WEST SUSSEX COUNTY COUNCIL CONSULTATION

TO:	Arun District Council FAO: Silvie Steiningerova
FROM:	WSCC – Highways Authority
DATE:	6 November 2025
LOCATION:	Yew Tree Cottage 11 Ferring Street Worthing BN12 5HL
SUBJECT:	FG/136/25/L Listed building consent to form a new vehicular access following the removal of gate and demolition of wall. (This application may affect the character and appearance of the Ferring Conservation Area).
DATE OF SITE VISIT:	n/a
RECOMMENDATION:	Advice

PROPOSED NEW ENTRANCE & DRIVE TO YEW TREE COTTAGE, FERRING ST. BN12 5HL
 DRWG. NO. 11/01 JULY 2025

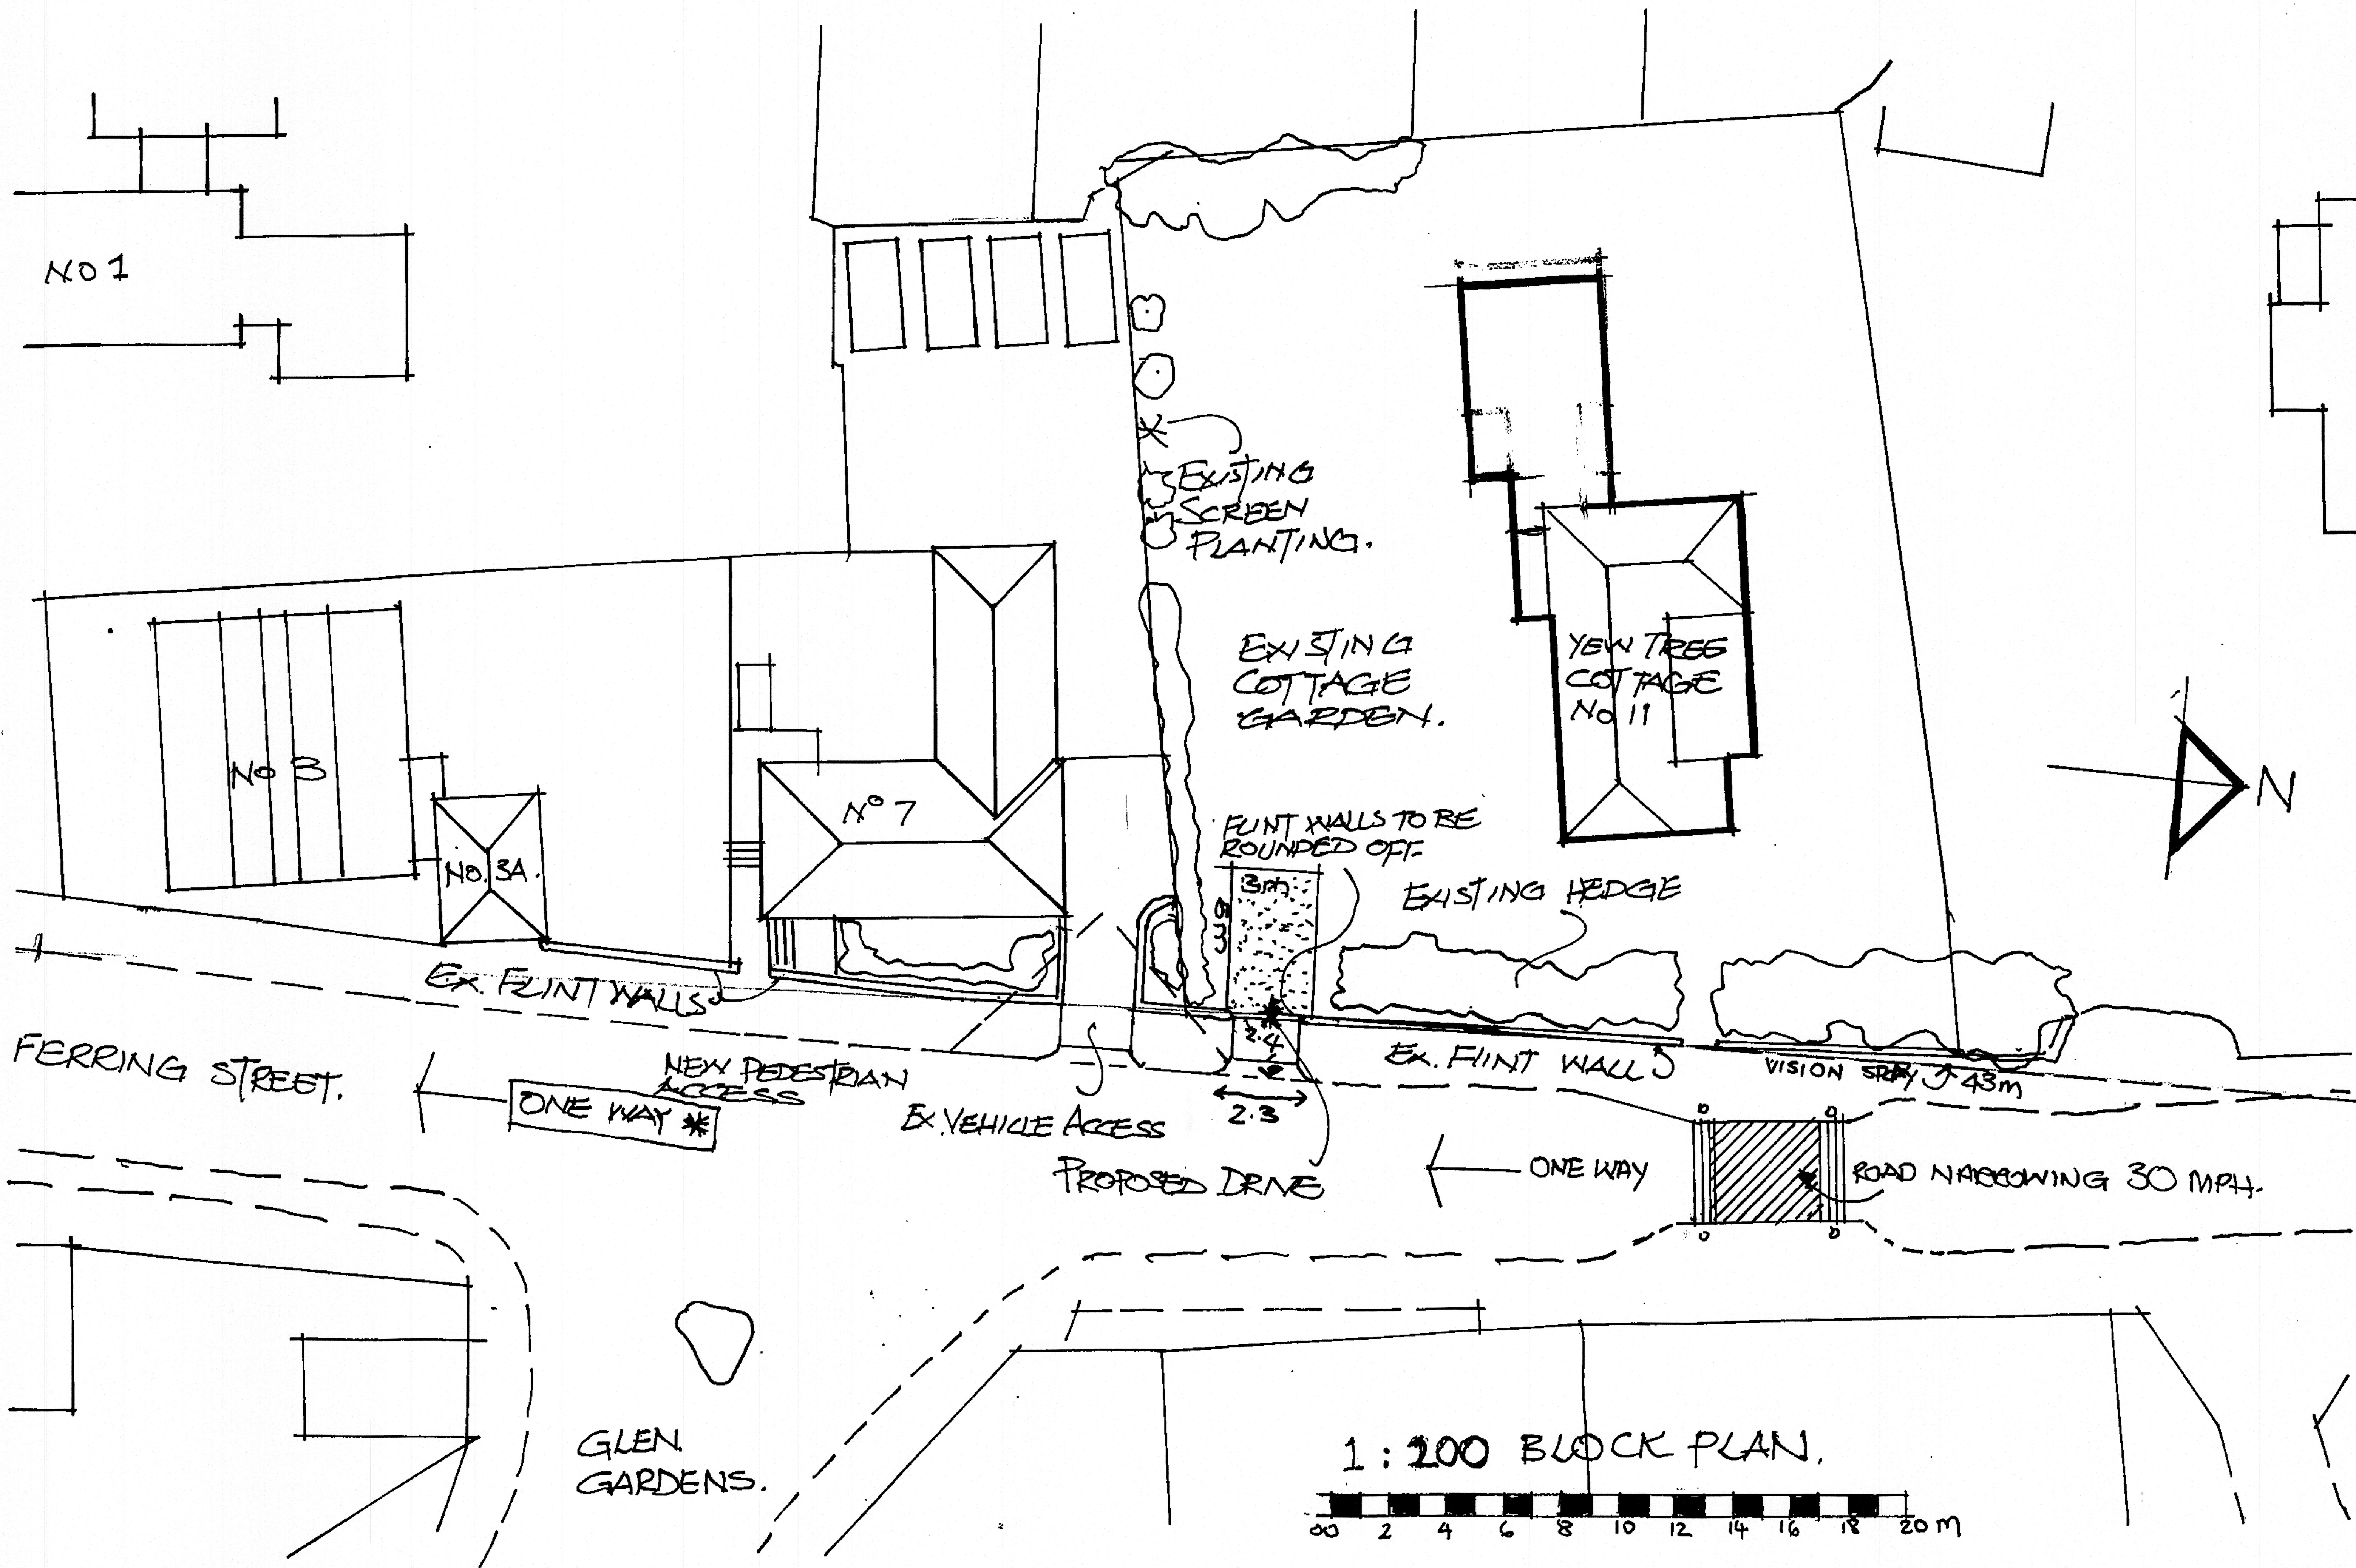
The proposed vehicular crossover is demonstrated on the plans as 2.3m wide at the carriageway edge. The applicant should be aware that the VCO works would be subject to a licence from the WSCC Area Engineer and must be constructed to a specification agreed with them - the minimum VCO width is 4.5m (including transitional kerbstones). Details of the proposed access width and geometry can be dealt with via condition.

The plans indicate that the proposed aperture in the flint wall will be 2.4m in width. Swept path tracking has not been provided to demonstrate that a vehicle could manoeuvre into the proposed parking area in one movement.

The LHA consider that a wider gap within the wall would provide a more practical access width for a vehicle and reduce the opportunity for vehicles to collide with the wall. However, the LHA consider that the aperture, as proposed, is sufficiently wide enough to fit a vehicle; although it may require a vehicle to move into a suitable position within the carriageway to carry out the manoeuvre, or to conduct a multi-point manoeuvre if not aligned properly on approach. The LHA would not raise any highway safety objection to the proposal on the basis of the site aperture width, given the nature of Ferring Street, with good forward visibility – it is considered likely that oncoming vehicles would have sufficient time to react to a vehicle manoeuvring within the carriageway.

Access (details required, access provided prior to first occupation)

The use of the parking area shall not commence until such time as the vehicular access has been constructed in accordance with plans and details to be submitted to and approved in writing by the Local Planning Authority.
